Recommendation Report for Planning Permission for Works or Extension to a Dwelling

REF NO: BE/108/21/HH

LOCATION: 9 Bedford Avenue
Bognor Regis
PO21 5AW

PROPOSAL: Single storey rear extension

GROUND FLOOR PLAN ~ AS PROPOSED

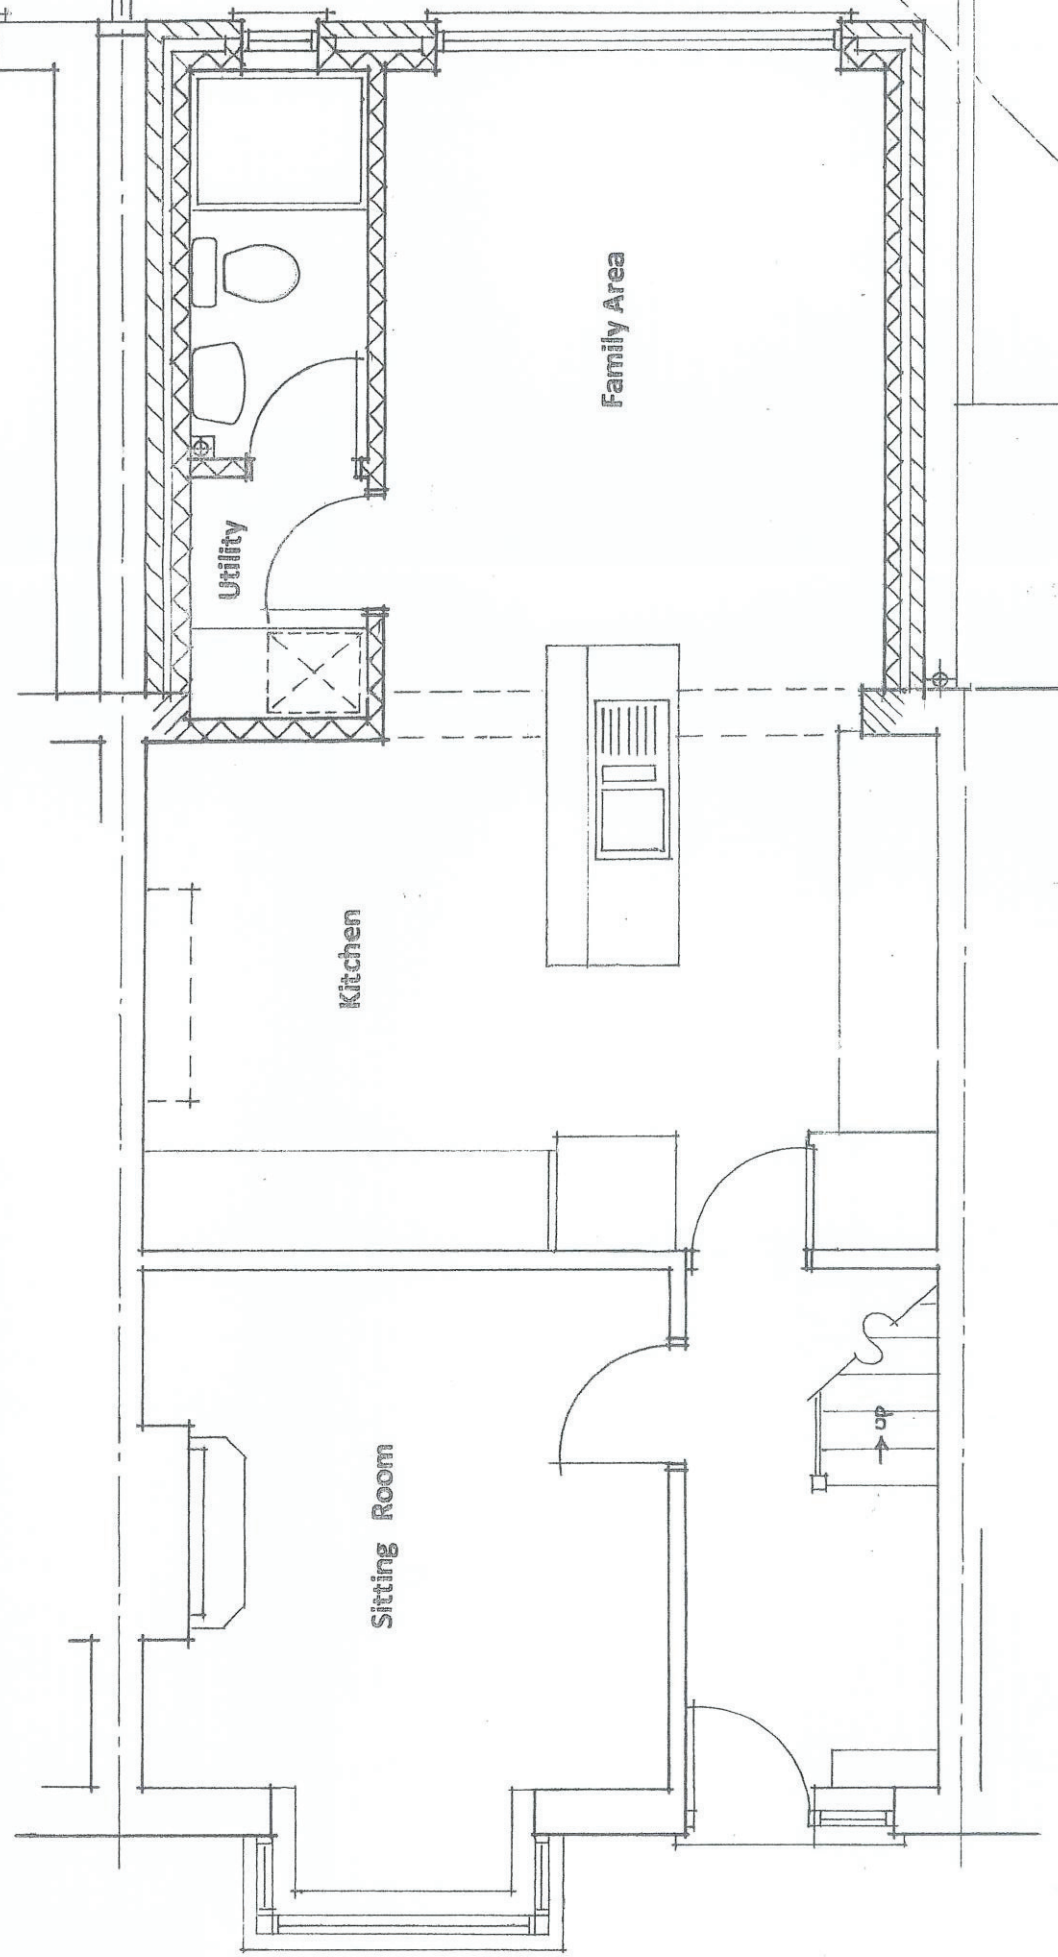
The proposal will have a width of approximately 5.16m and a depth of approximately 4.46m. The height to top of roof ridge line will be approximately 3.97m. There will be one new double sliding door to the rear and one new single window to rear. There will be one new roof light to centre of roof plane.

The extension will have a width of approximately 5.16m and a depth of approximately 4.46m. The height to top of roof ridge line will be approximately 3.97m. Due to the siting to rear and gap of only 0.33m remaining to both east and west boundaries there is increased risk to overshadowing or overbearing effects to neighbouring properties. However due to being at single storey and the presence of extensions at both neighbours and location of existing boundary fence the degree of overshadowing or overbearing effects are reduced and it is considered acceptable.

REAR ELEVATION ~ AS PROPOSED

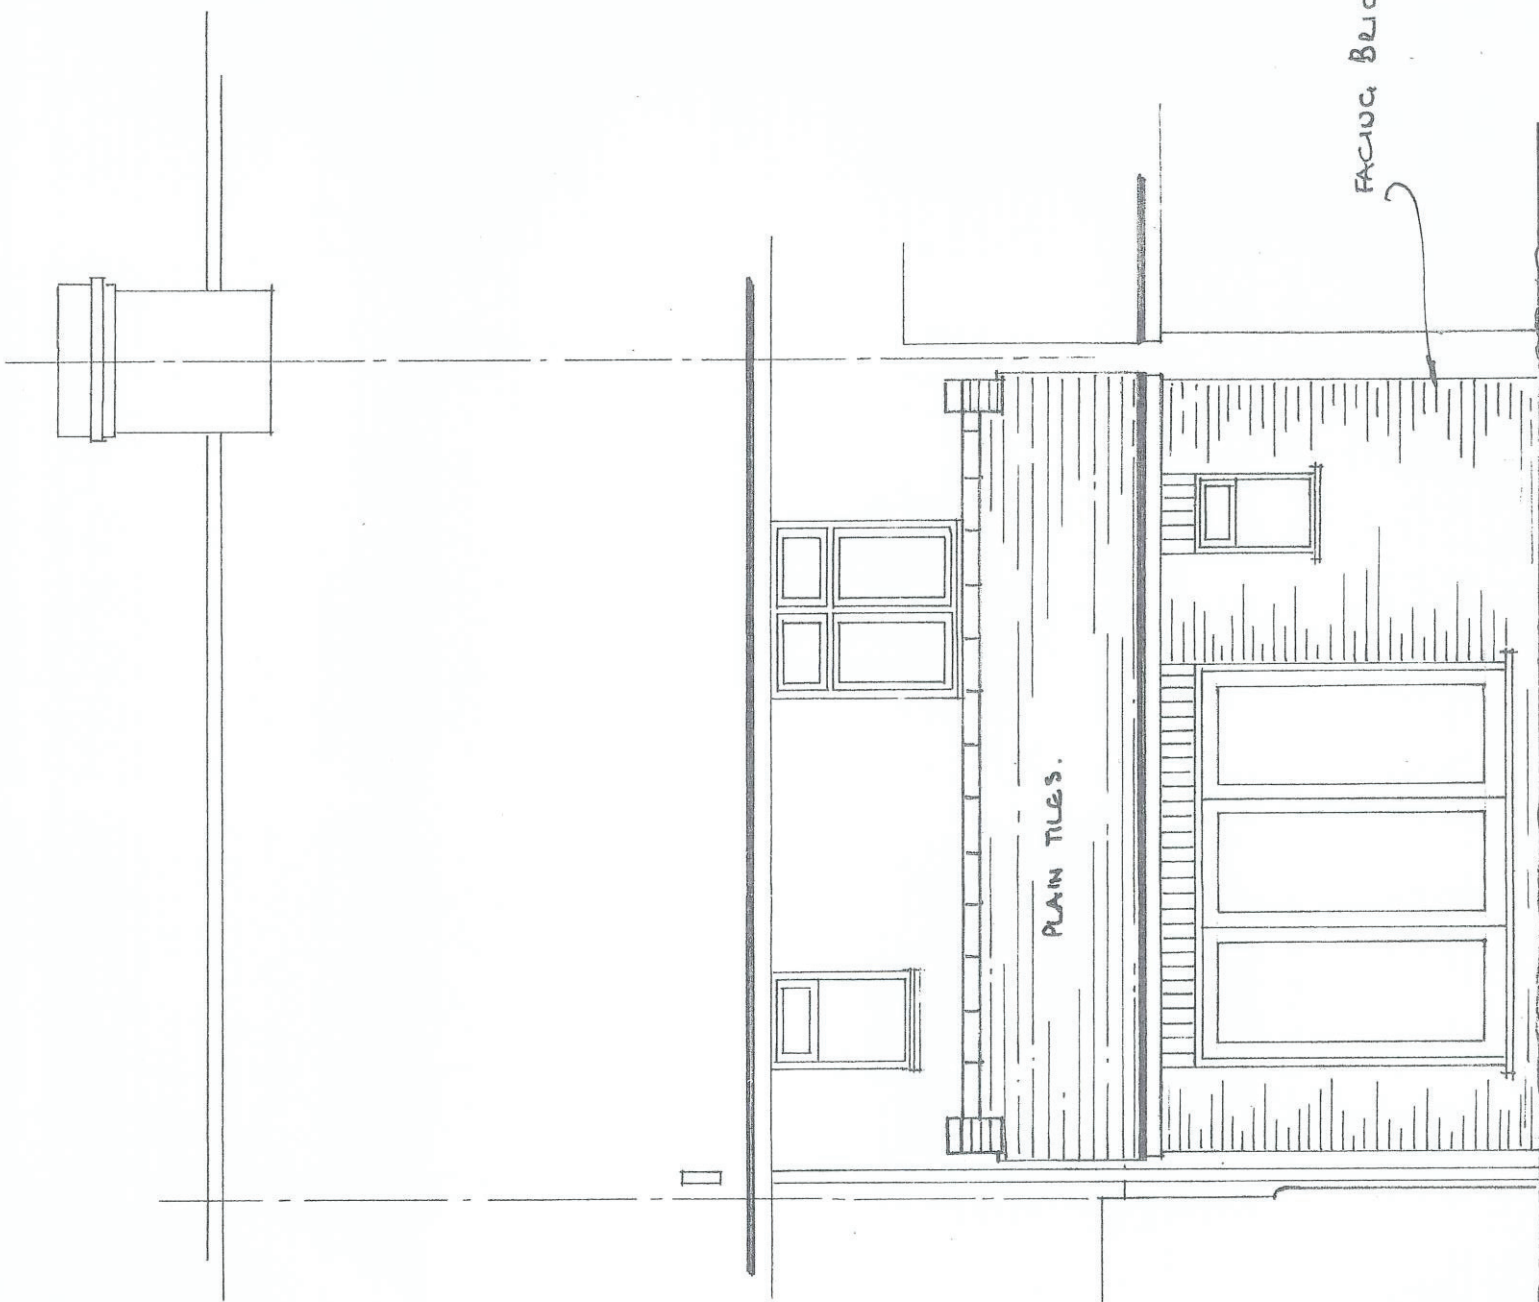
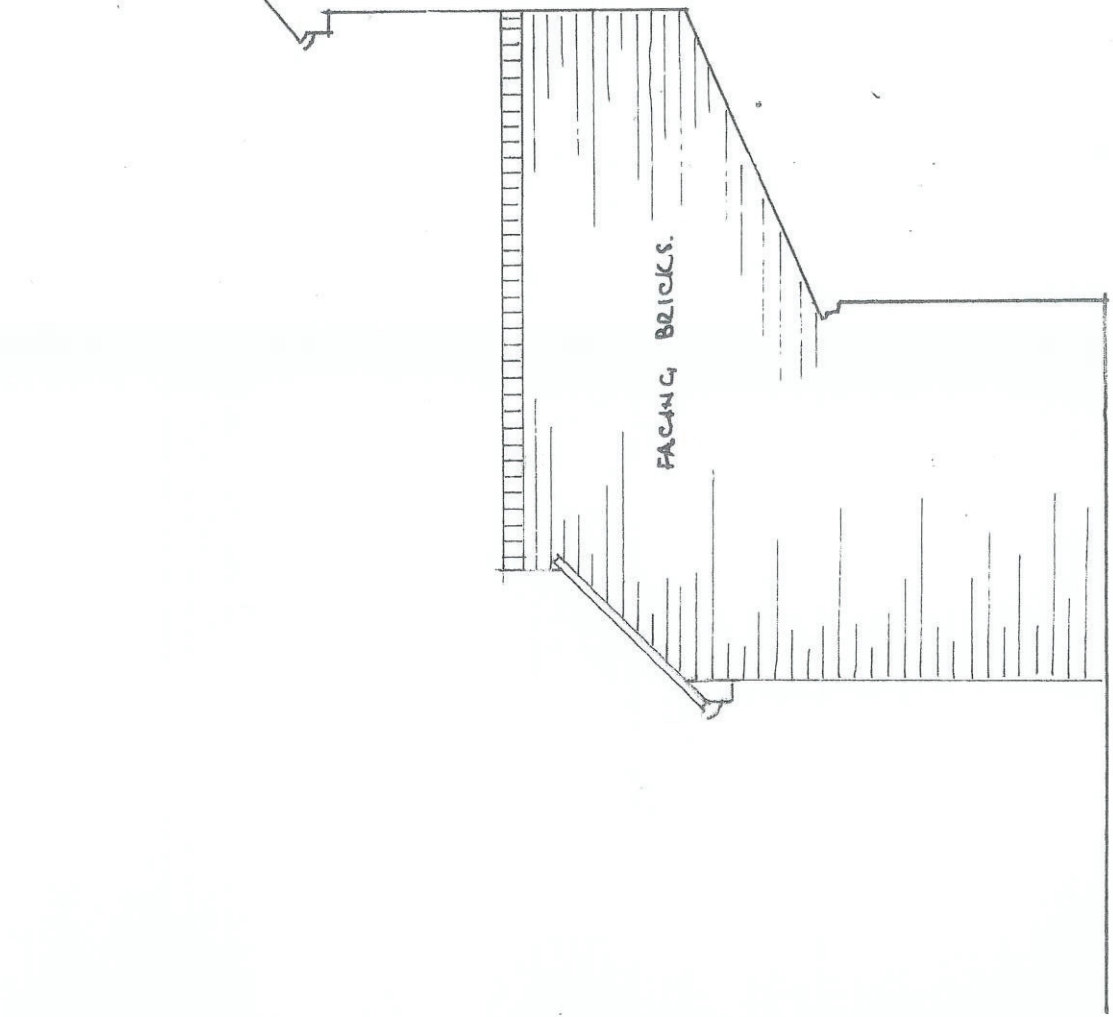
The materials consist of facing brickwork walls, plain roof tiles and felt flat roof materials, UPVC windows and aluminium doors so complies with policies D DM1 and D DM4 of the Arun Local Plan and ESD1 of the BNP.

Due to the new door and new single window to rear there is increased risk to overlooking to neighbouring properties to east and west however due to being at single storey and existing boundary fence to east and west there is no adverse harm to overlooking to east or west. Due to large gap of around 13.04m remaining to rear boundary and no direct neighbours to north there is no adverse harm to overlooking to neighbouring properties to north so is acceptable.
